**Consultation Response from KC,  
Highways Development Management**

**2023/90491 Teas Me, 6, Albert Street, Lockwood, Huddersfield, HD1 3PR**

**Erection of extension to existing building for outdoor dining/smoking use**

**Date Responded: 07/09/2023.**

Title: Proposed Site Plan	Drawn: HA
Client: Tea's Me Cafe	Checked:
Date: 13-09-2023	Paper: A3
Drawing No: HAD3462-05	Scale: 1:200
Revision:	a

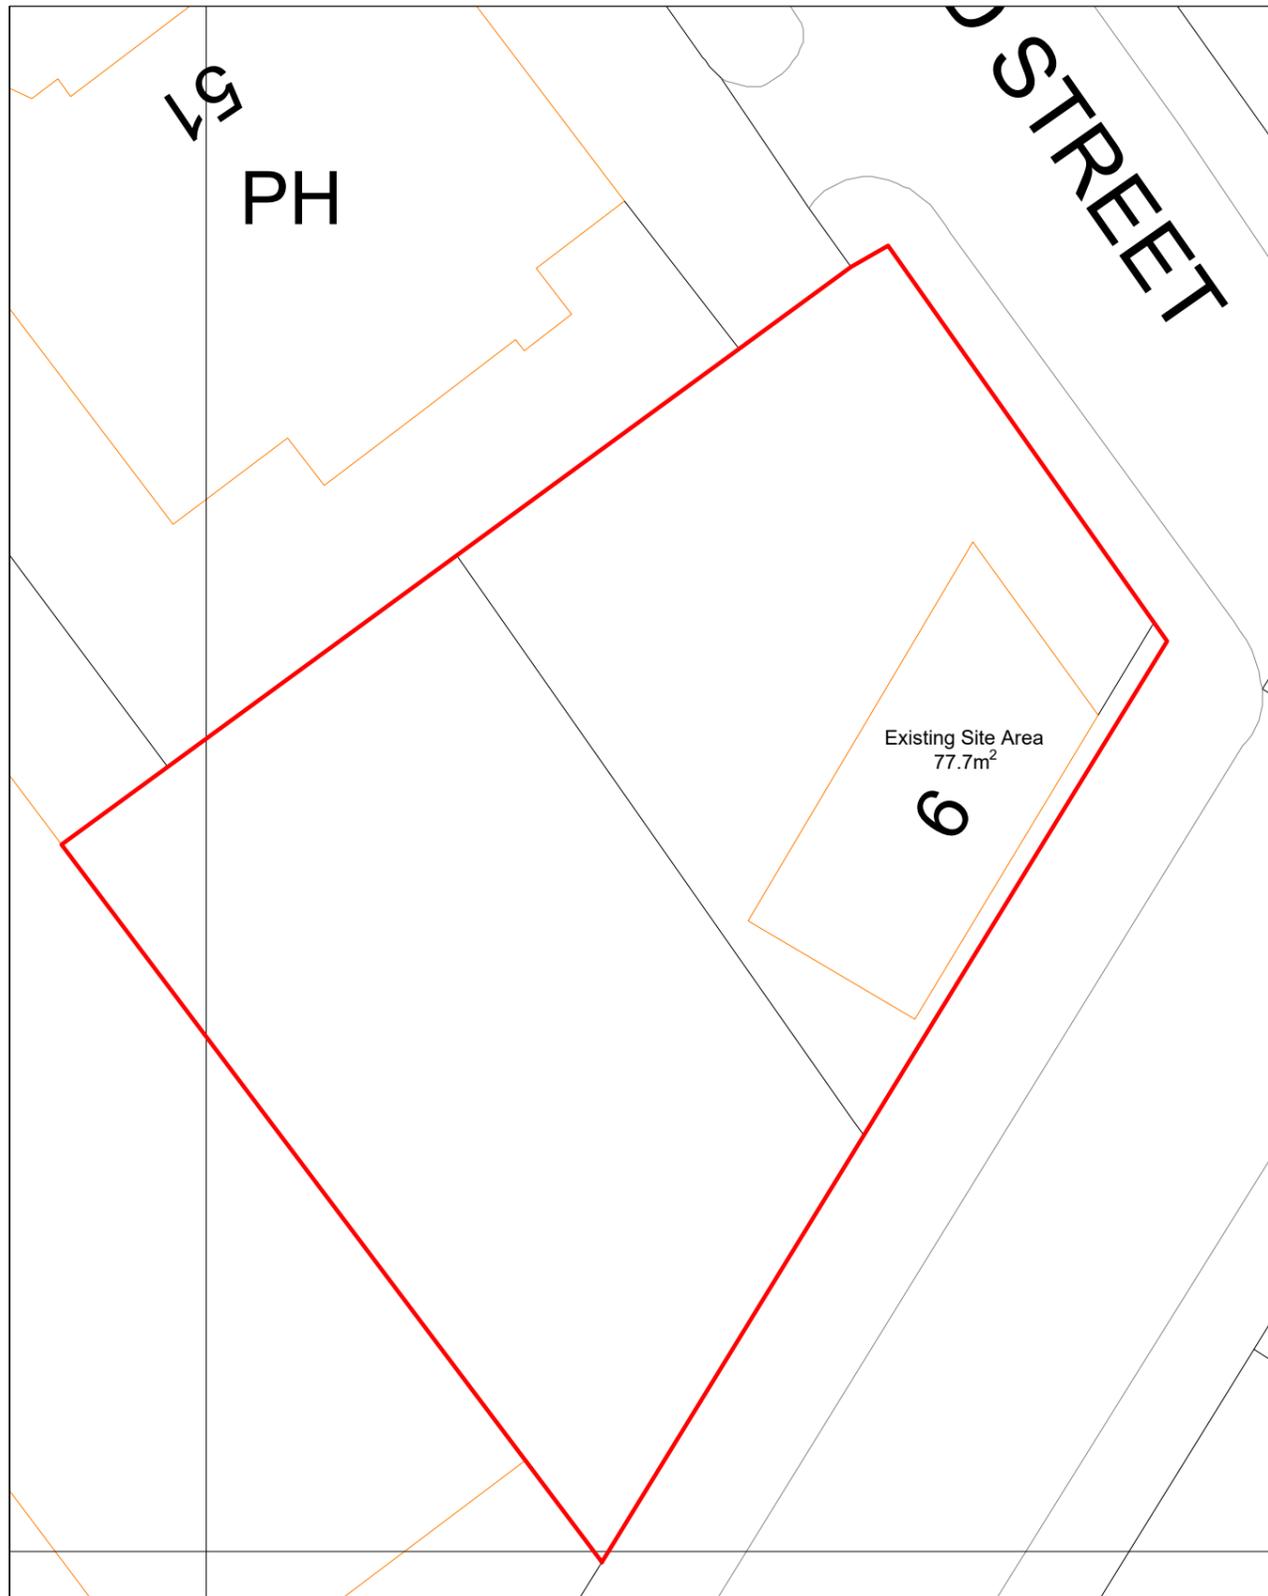
However, Drawing No. HAD3462-05 shows that the floorspace of the existing café is 114 sq. m and the proposed extension is 102.5 sq. m giving a total area of 216 sq. m

The car park layout does not work as proposed.

To enable vehicles to access the parking spaces a central aisle width of a minimum of 6m is required.

The proposal shows an aisle width of only 4.3 metres which is too narrow to enable a vehicle to turn into or out of the car parking spaces.

One of the rows of parking needs to be turned through 90 degrees to allow a suitable aisle width to be provided.

Title: Existing and Proposed Site Plans	Drawn: HA
Client: Teas Me Cafe	Checked:
Date: 17-01-2023	Paper: A3
Drawing No: HAD3462-06	Scale: 1:200
Revision:

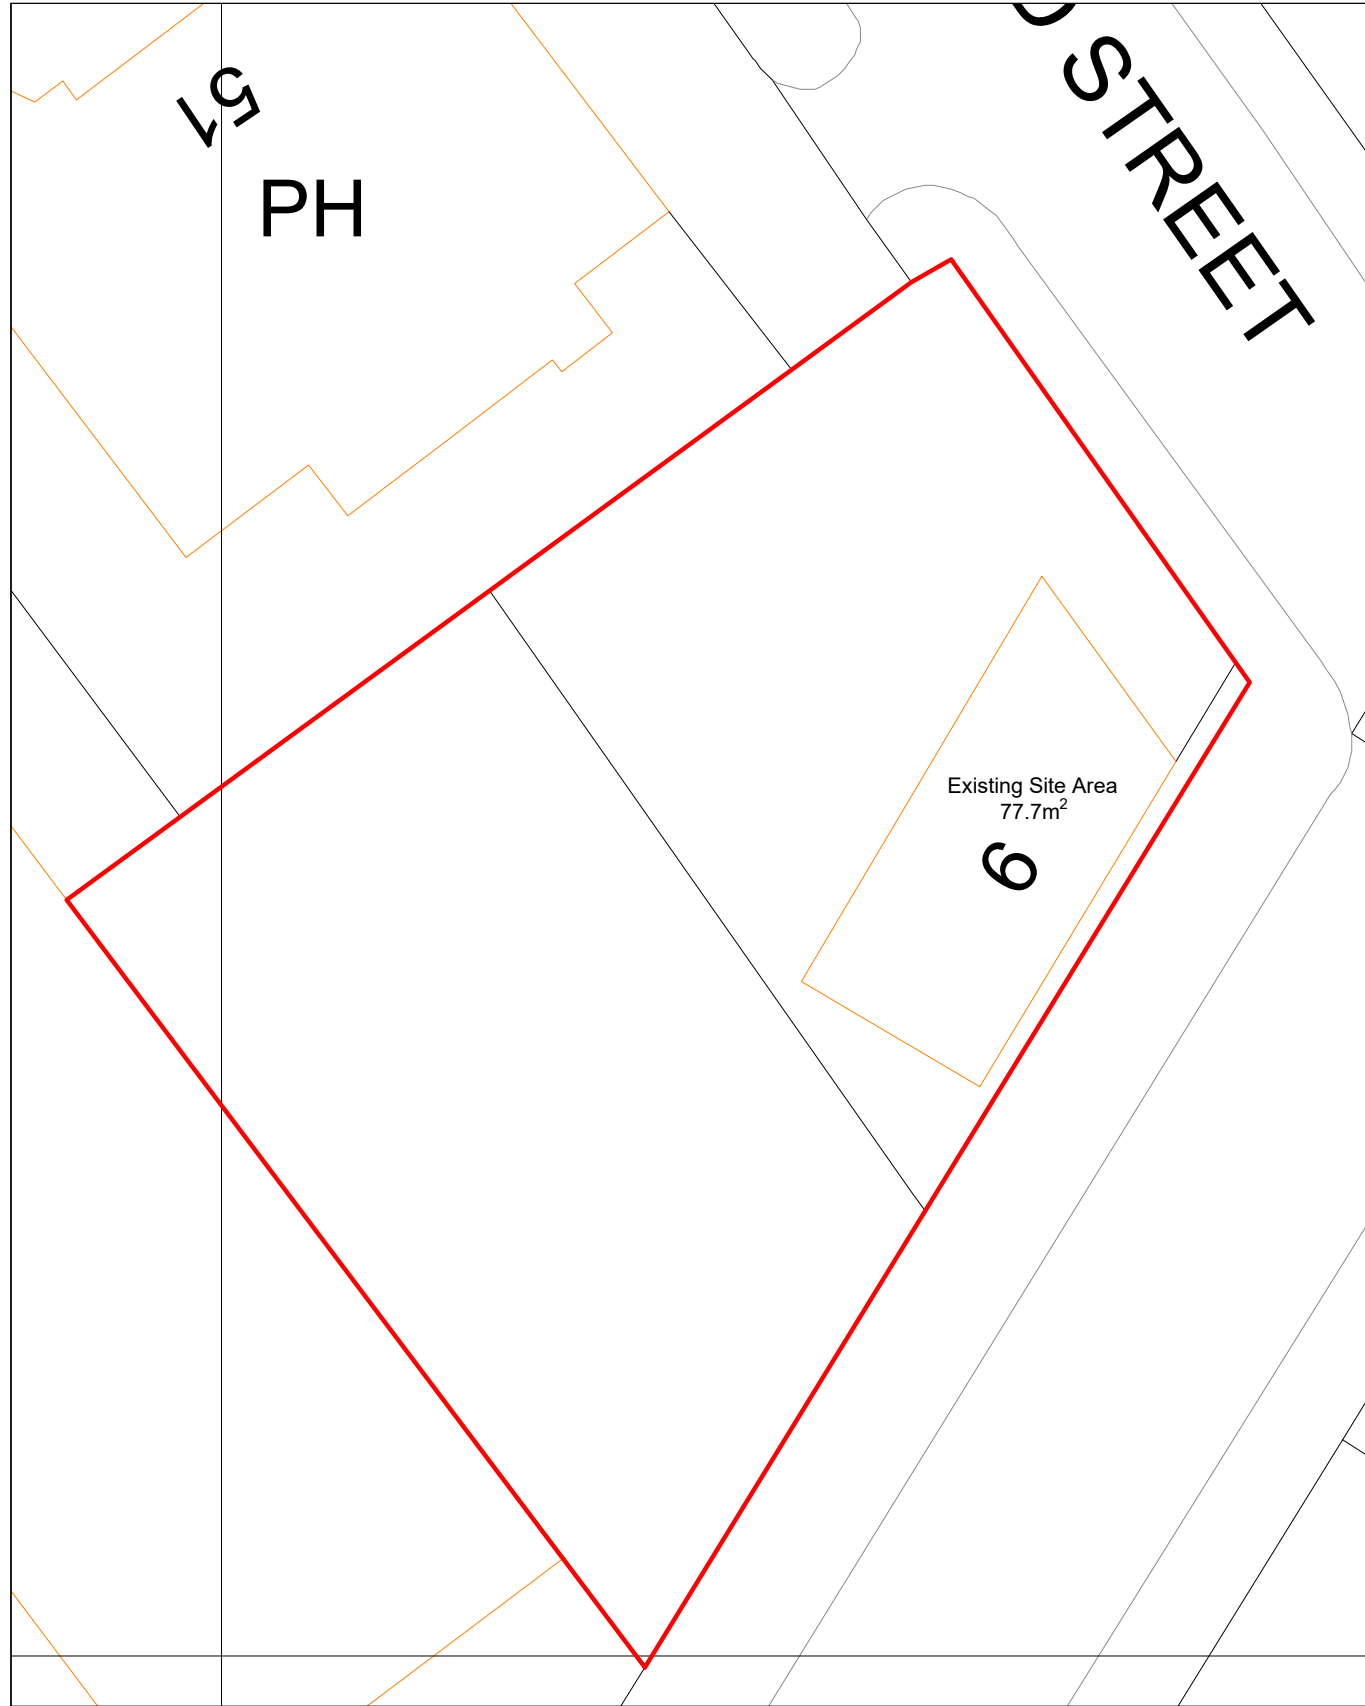
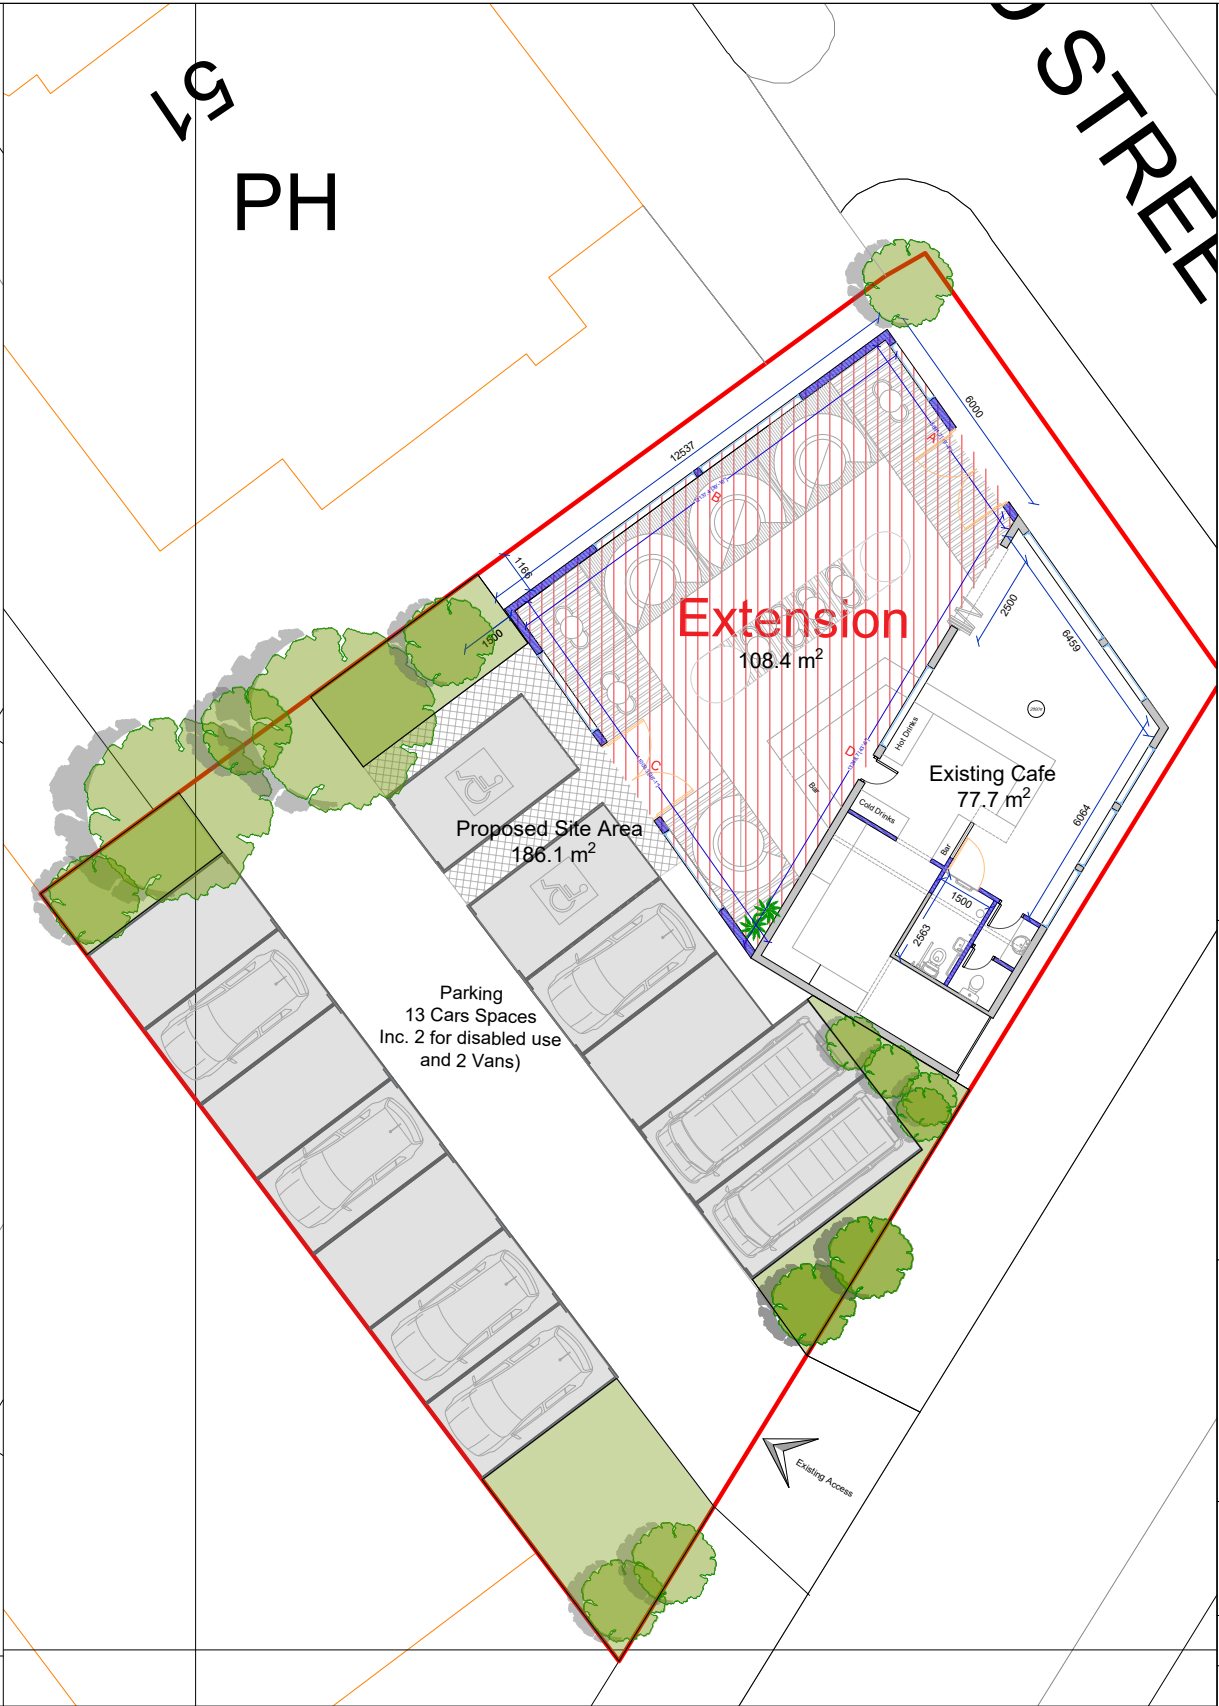
As a result, the car park would need to be reconfigured to make it fit for purpose.

This will result in reducing the proposed parking numbers to approximately 9 usable car parking spaces.

This number would be acceptable if the proposed extension is for a total of 108.4 sq. m. as stated in the application form. However, if the proposed extension is for a total of 216 sq. m as shown on the submitted plans then the shortfall in the number of required parking spaces for this size of development could not be supported.
